Subdivision Comments

RE: SP-23-00001 Egan Short Plat

EGAN SHORT PLAT

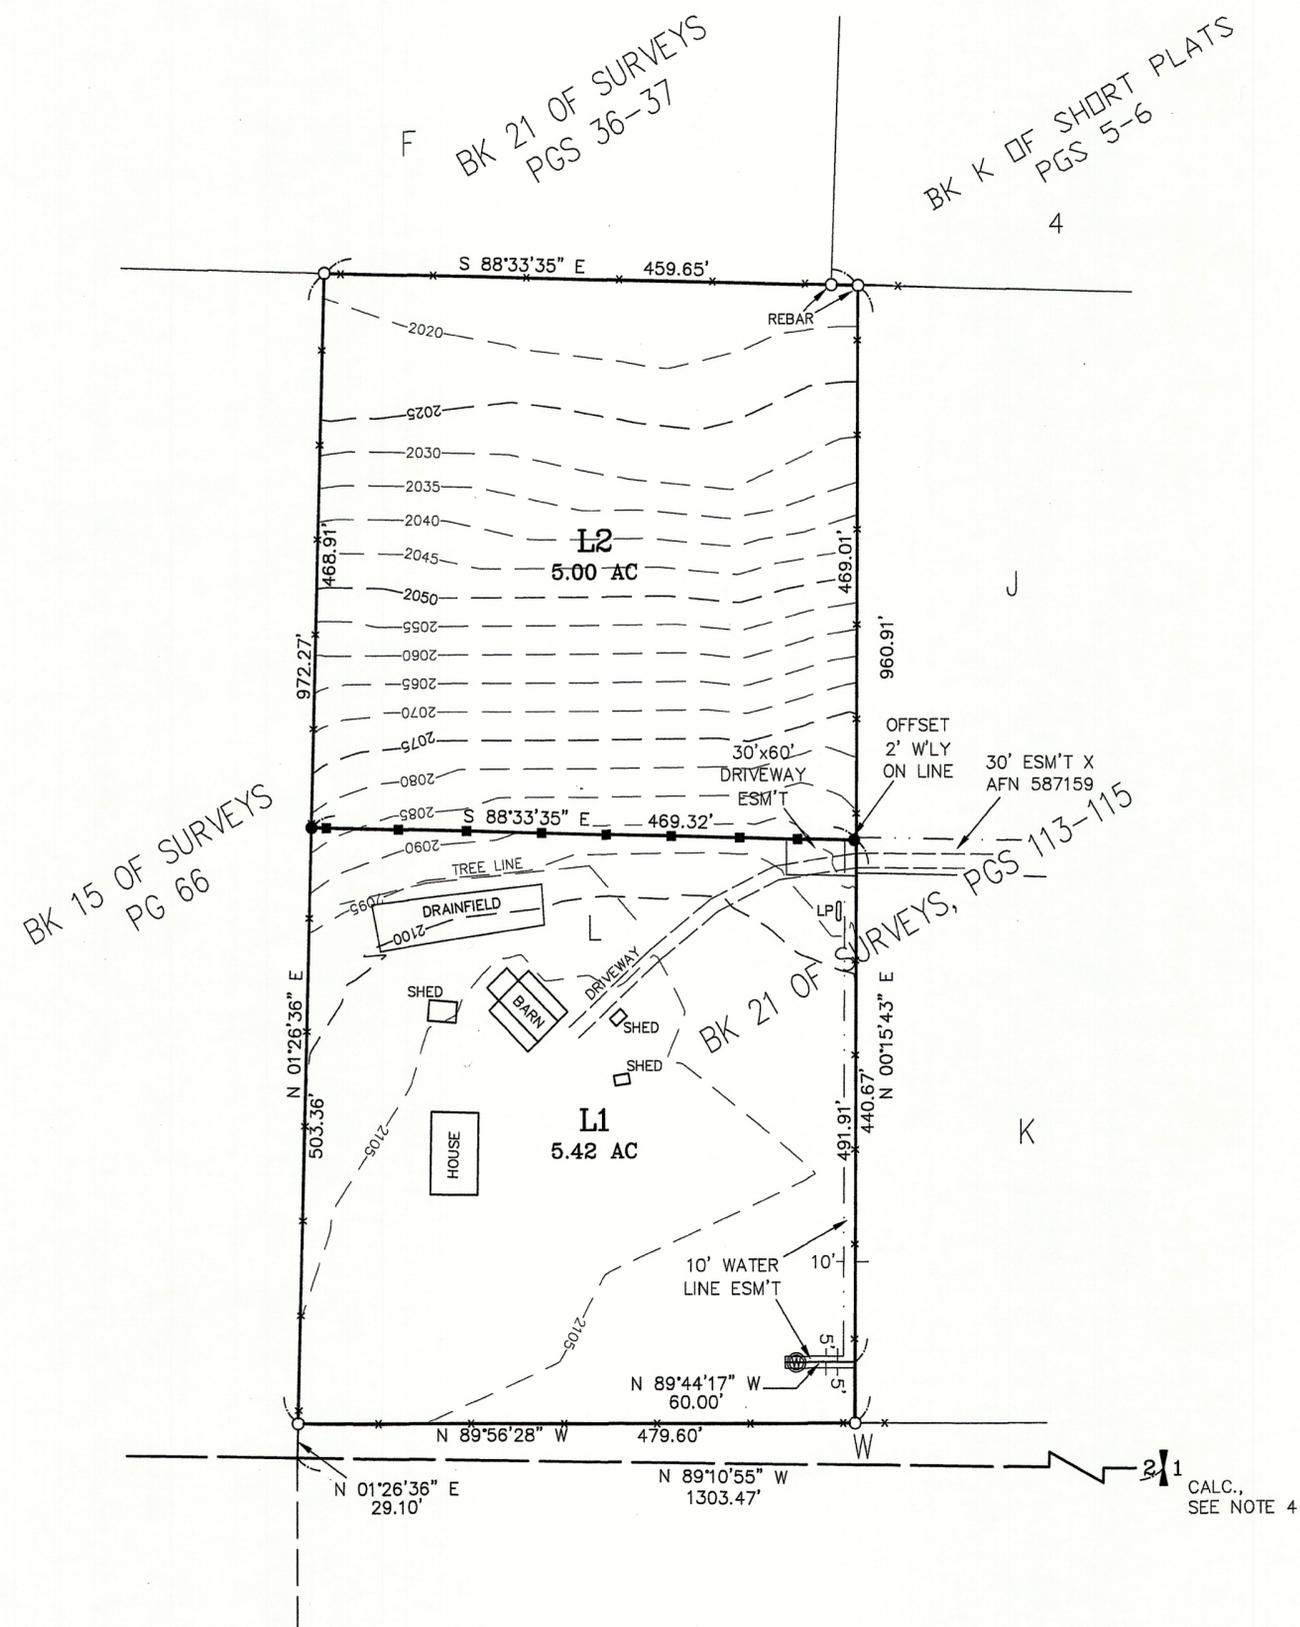
Proposed short plat indicates shared wells will be used. If the intention is to utilize a shared well, a signed, notarized, and filed shared well users agreement will also need to be provided before the short plat is finalized. If shared wells are to be utilized, the wells must be drilled a minimum of 50 feet from any proposed property line and a signed, notarized and recorded shared waters users' agreement for each shared well must be submitted to our office prior to final plat approval. The applicant must prove physical availability of water for all new uses of water proposed lots of this project, which can be provided by (See Condition A-1) a well log or 4 hour draw down test as proof of water availability for each new well proposed. All persons who

A signed and recorded shared water user's agreement between proposed lots is needed. Along with a current water right for the proposed lots.

A-1 13.35.020(b) requires proof of adequate water supply, which can be submitted through a well log or 4 hour draw down test if an existing well is used and is older than 10 years. If shared wells are used, a signed, notarized, and recorded shared well-users agreement must be submitted. All individual and shared wells must meet the distance requirement of 50 feet from the property line, 50 feet from the septic tank and 100 feet from the drain field as per Kittitas County Critical Areas Ordinance 17A.08.25, and KCC Chapter 13.
